CITY OF MERCER ISLAND

Pre-Application Meeting (PRE22-012)

Site Location:	6221 83 rd PI SE	Parcel Number	545420-0220
Lot Size:	10,017 sf	Zoning:	R-9.6 (Single Family)
Brief Project Description:	Demo existing SFR. Build new SFR. Located in geohazard areas.	Documents Provided:	Project narrative, preapplication questions, conceptual plans, arborist report.
Applicant Information:			
Name:	Julian Weber	Email:	dpd@jwaseattle.com
		Phone:	(206) 953-1305
Second Pre-application Meeting Required:	Not Applicable	Click for explanation if necessary

1 Diagram Average Building Elevation
SCALE: 1" = 10'-0"

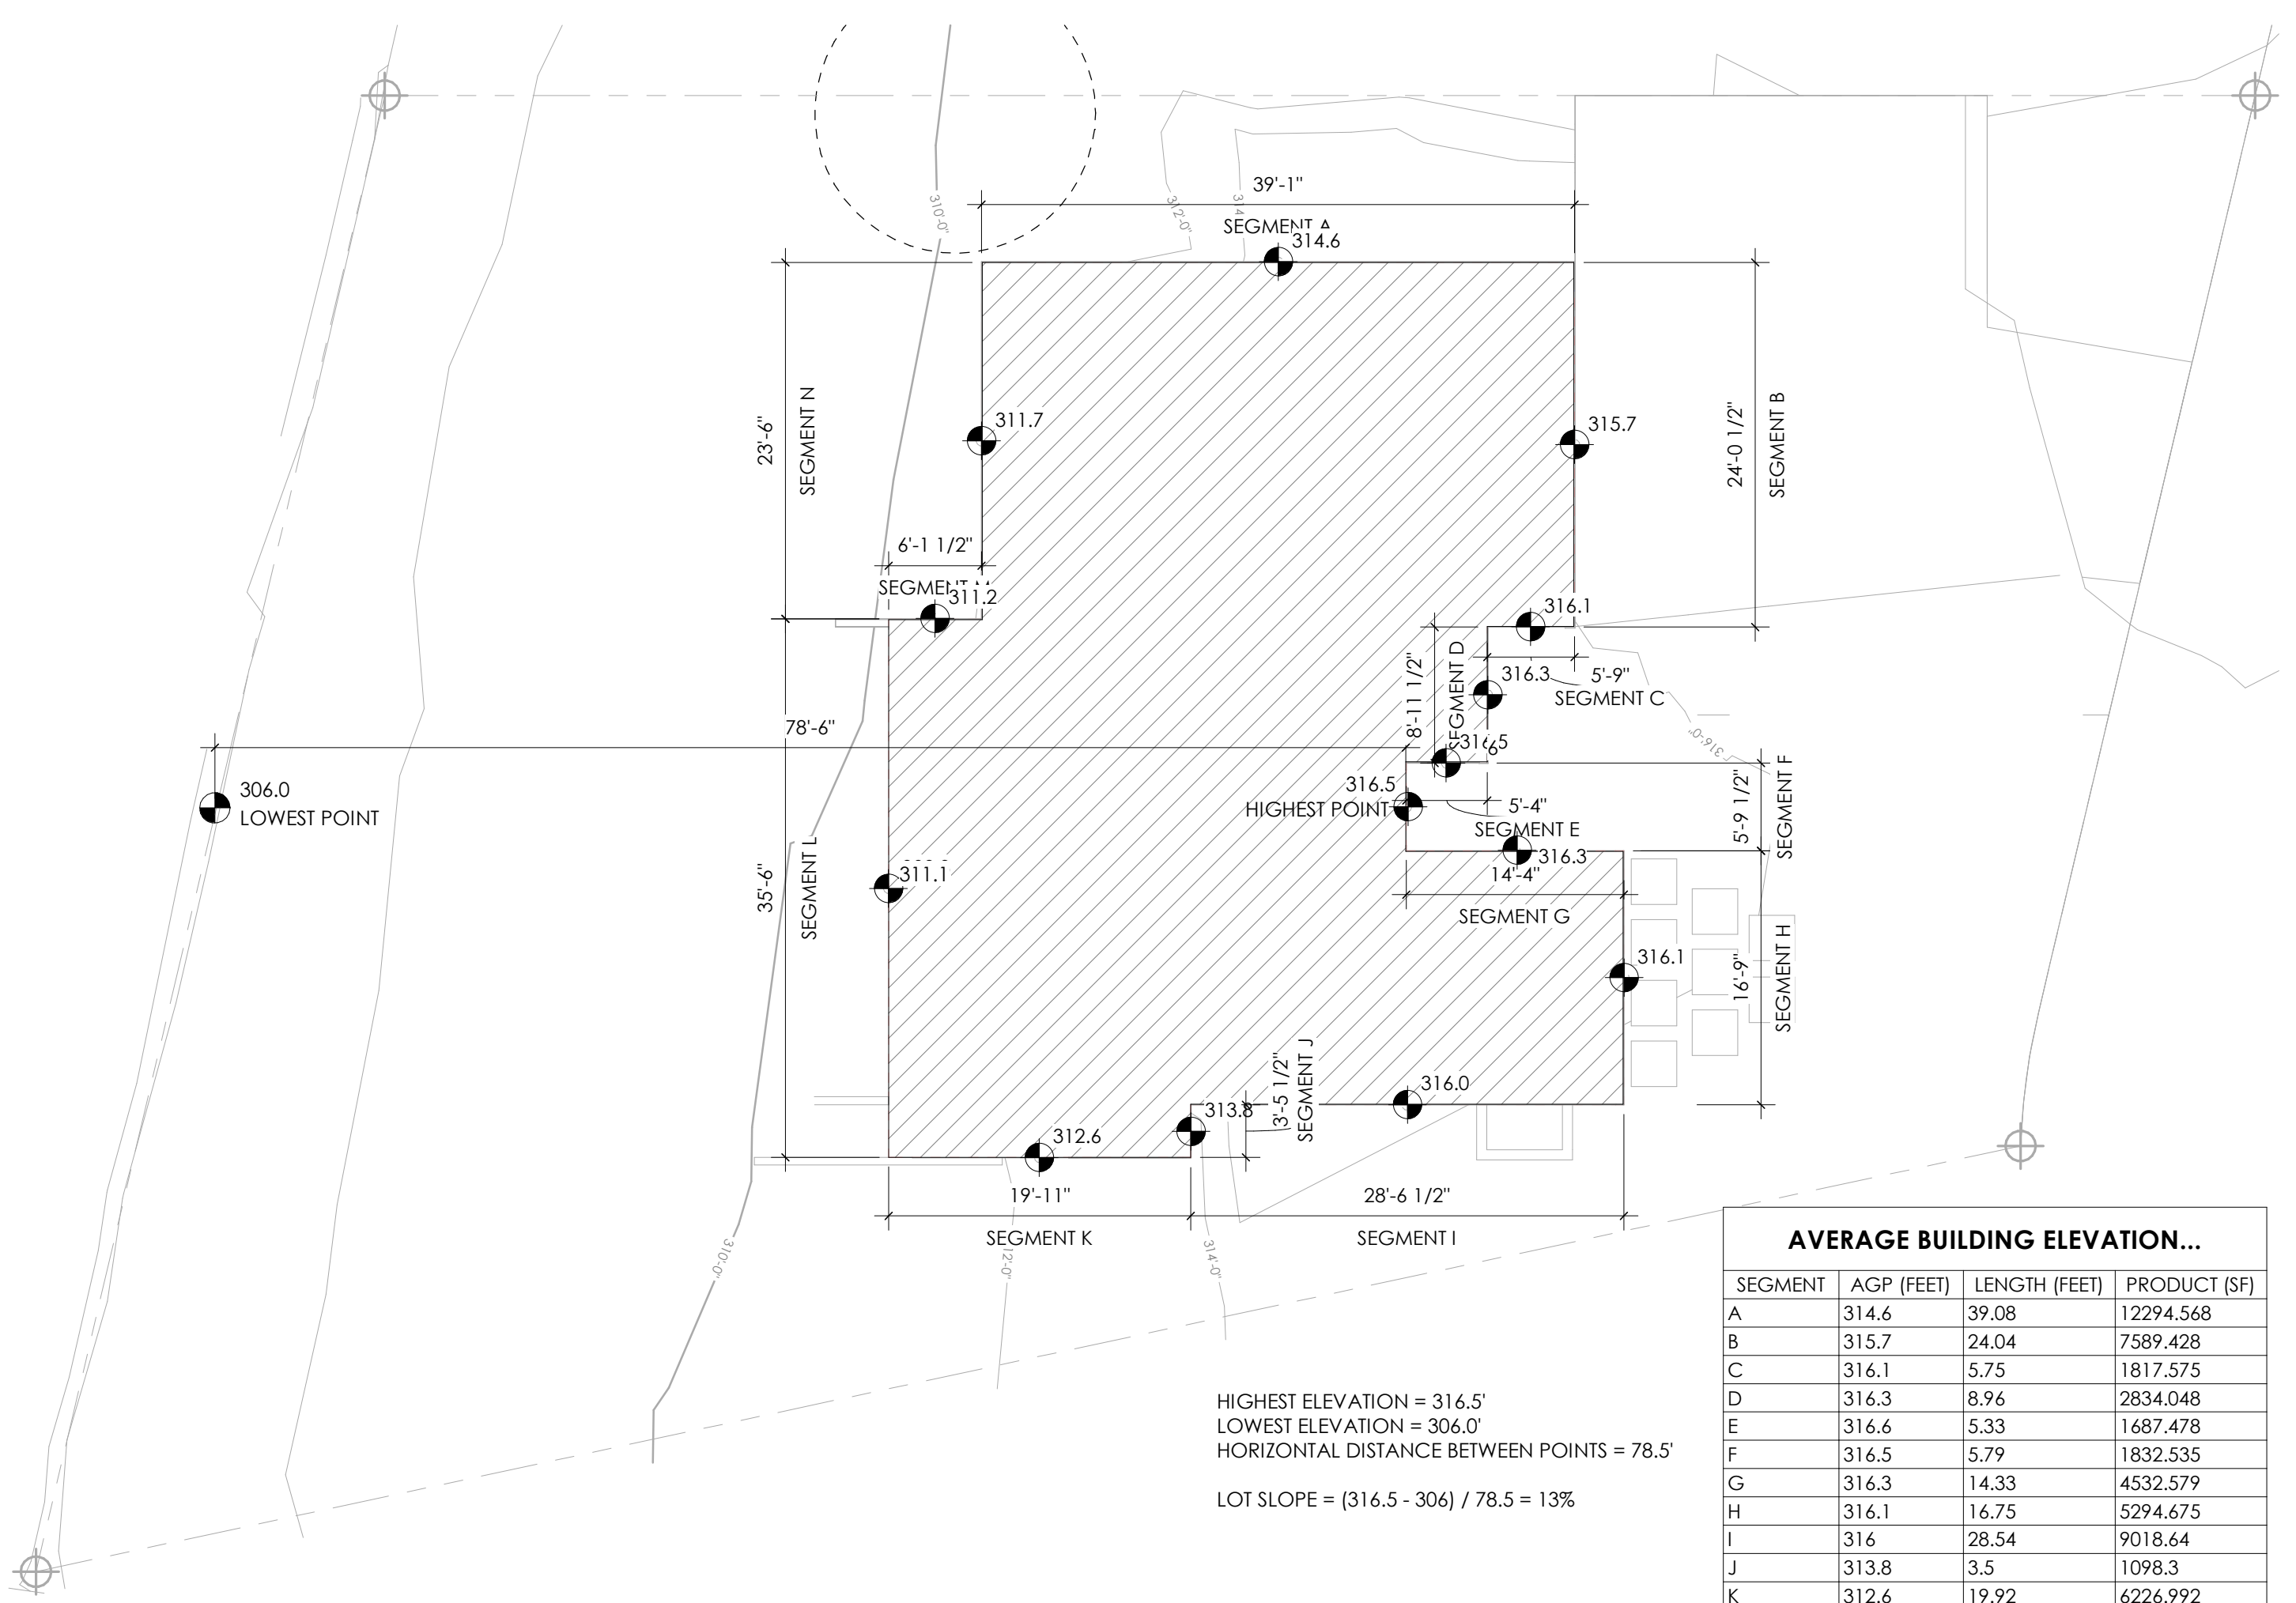
- b. Height:
 - i. 30 feet maximum above the Average Building Elevation (ABE) to the highest point of the roof (MICC 19.02.020.E.1). Note that ABE is calculated from the midpoint of each building segment to existing or finished grade, whichever is lower, directly below the midpoints. ABE calculations or finished grades were not provided, so we are unable to determine if ABE calculation is correct.

2 Diagram Setbacks
SCALE: 1" = 10'-0"

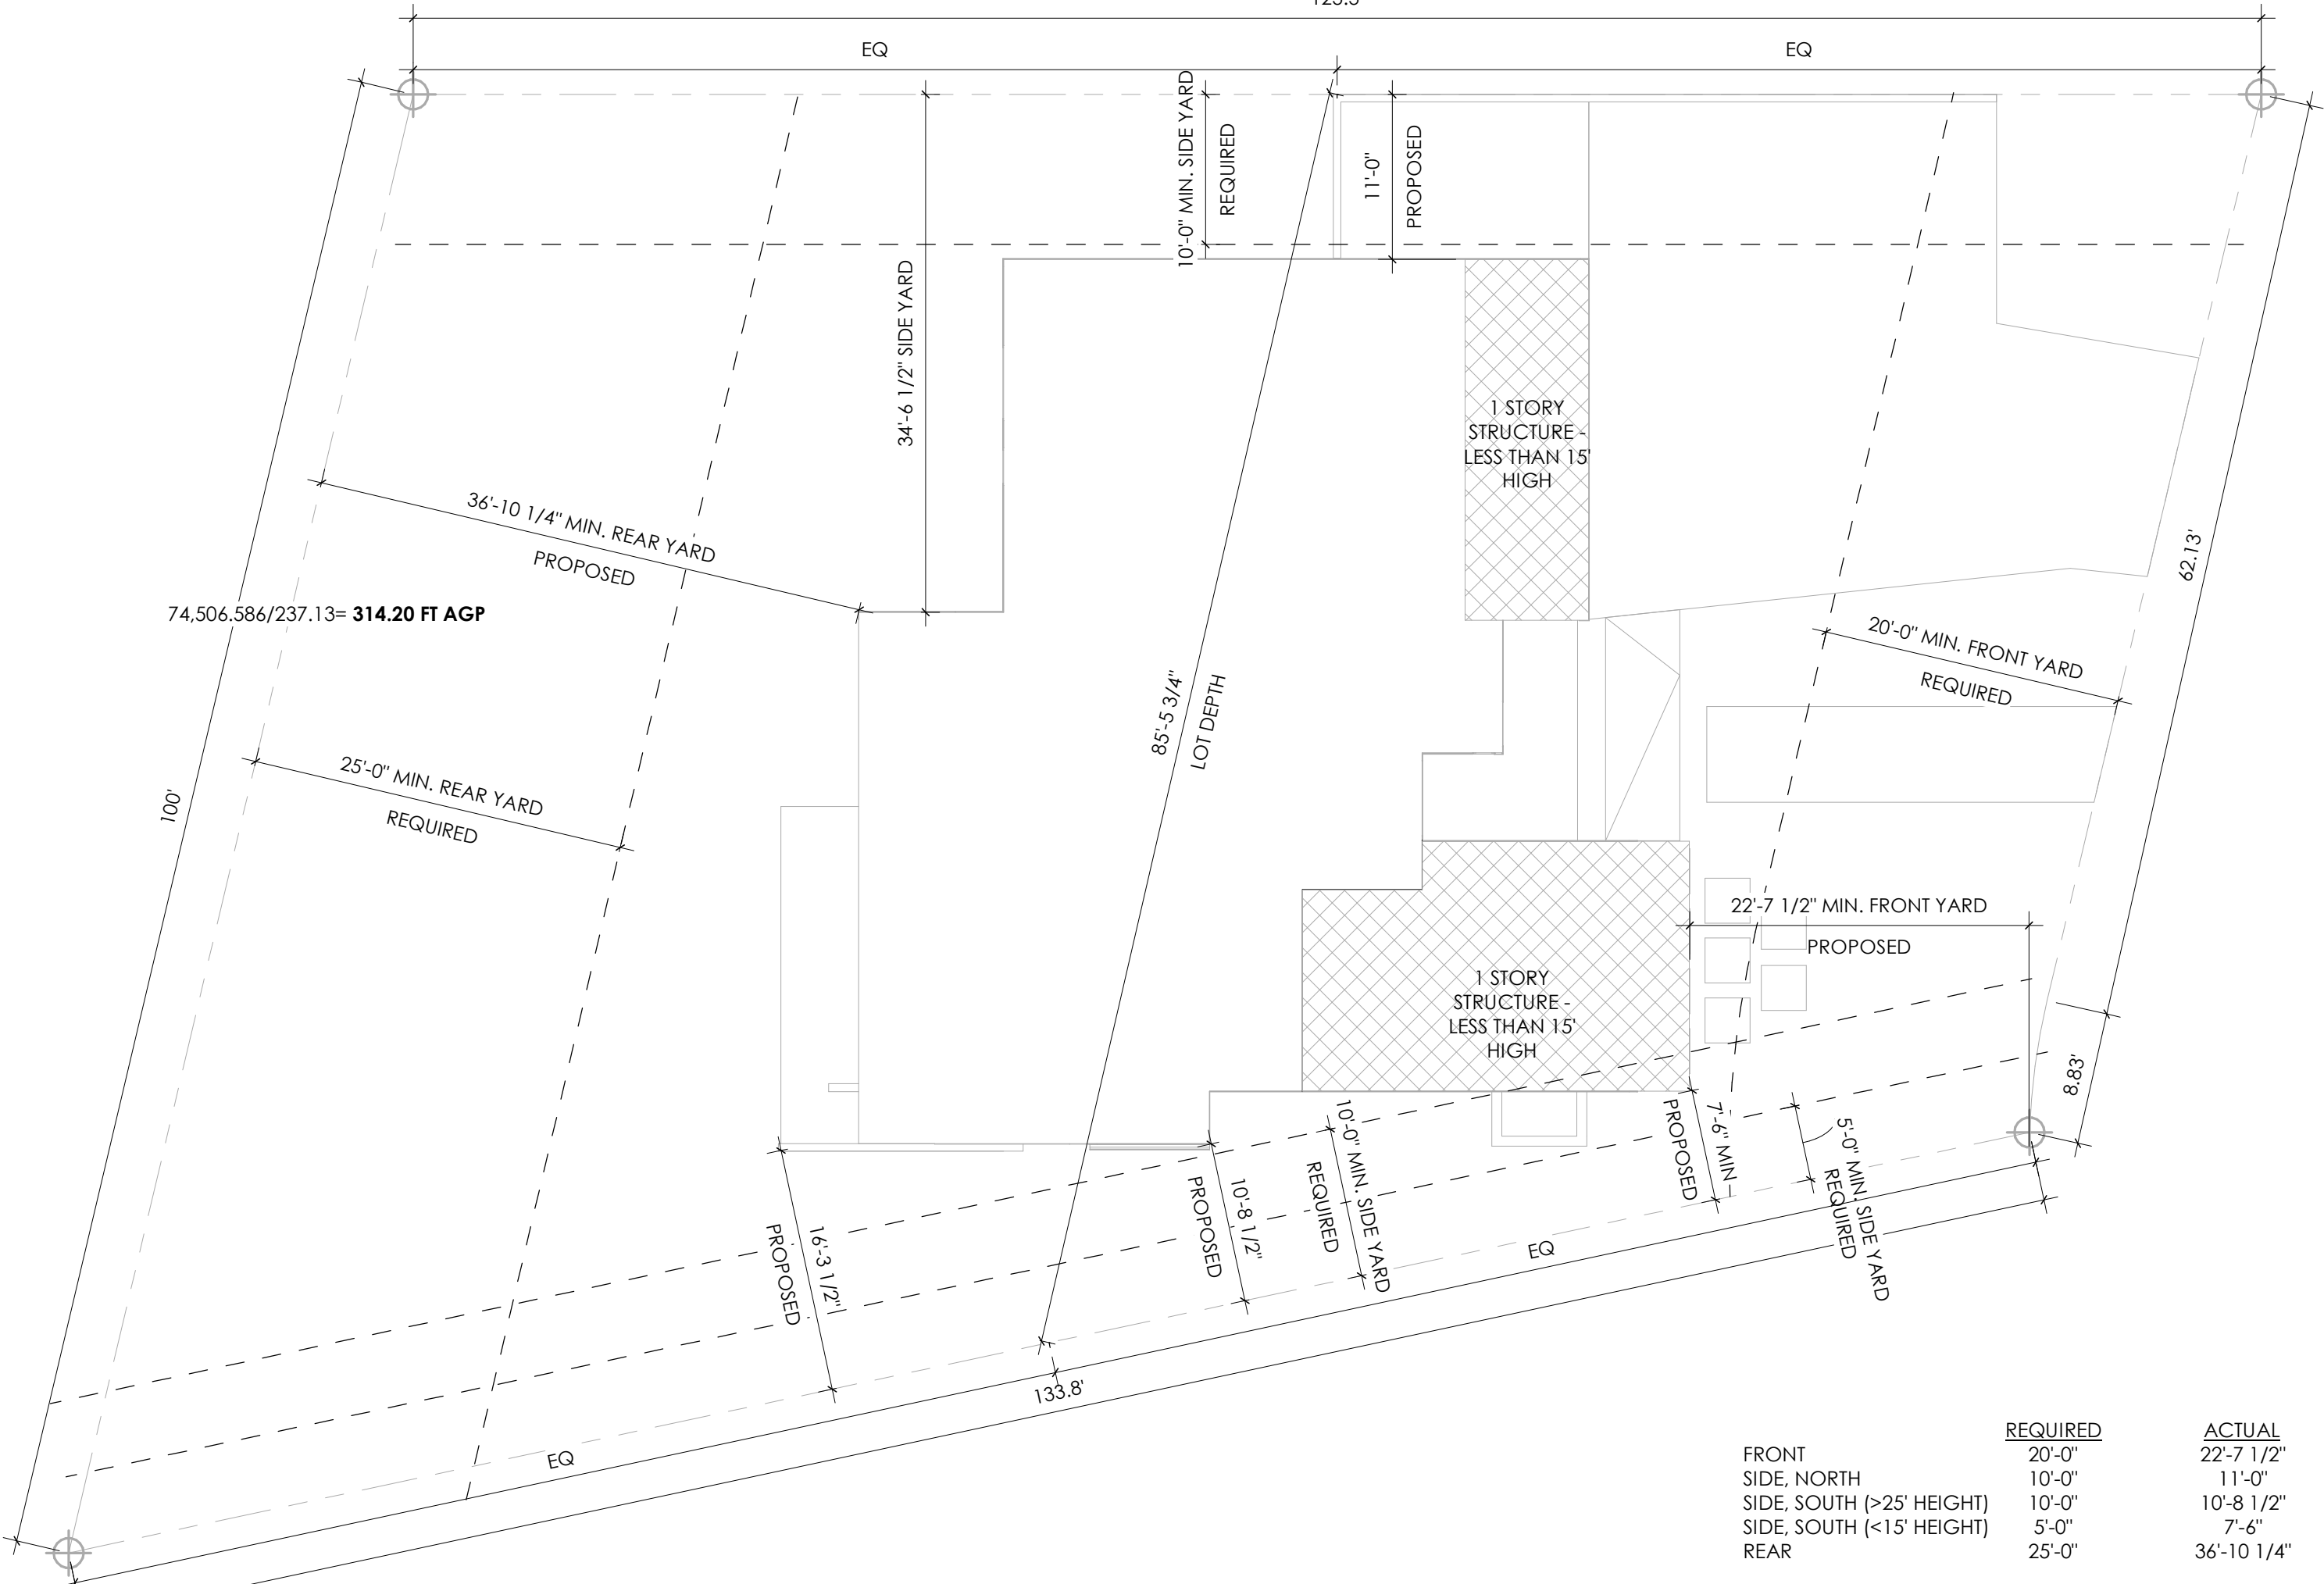
1. Residential Zoning Standards:
 - a. Yards
 - i. Front yard: 20 feet
 - ii. Rear yard: 25 feet
 - iii. Side yards:
 1. Requirements based on lot width: For an irregular shaped lot with four sides, lot width is calculated as the length of a line that connects the two midpoints of the side lot lines.

- a. If the lot width is 90' or less, the aggregate side yard setbacks are 15', and the minimum individual side setback is 5'.
 - b. If the lot width is greater than 90', the aggregate side yard setbacks are 17% of the lot width, and the individual side yard setback is 33% of the aggregate side yard requirement.

2. Variable Side Yard Depth Requirement:
 - a. Variable Side Yard Depth Requirements apply to interior lot lines only. Both side lot lines of the subject parcel are interior lot lines, so variable side yard setbacks apply. Additional side setbacks are based on façade height along the interior lot lines. Façade height is measured from existing or finished grade.

- b. A minimum side yard of 7.5 feet is required for 1) nongabled roof ends where the height is more than 15 feet; or 2) gabled roof ends more than 18 feet. Both measurements are taken from existing or finished grade, whichever is lower, to the top of the gabled roof end adjoining the side yard.

- c. A minimum side yard of 10 feet is required for single-family dwellings with a height of more than 25 feet measured from the existing or finished grade, whichever is lower, to the top of the exterior wall facade adjoining the side yard.

- iv. Note that penetration of eaves or other minor building elements (i.e. stairs) is not permitted into minimum side yard setbacks along interior lot lines (MICC 19.02.020.C.3.a.ii). Minimum side yard setbacks include side yard setbacks required by either lot width or by variable side yard standards.
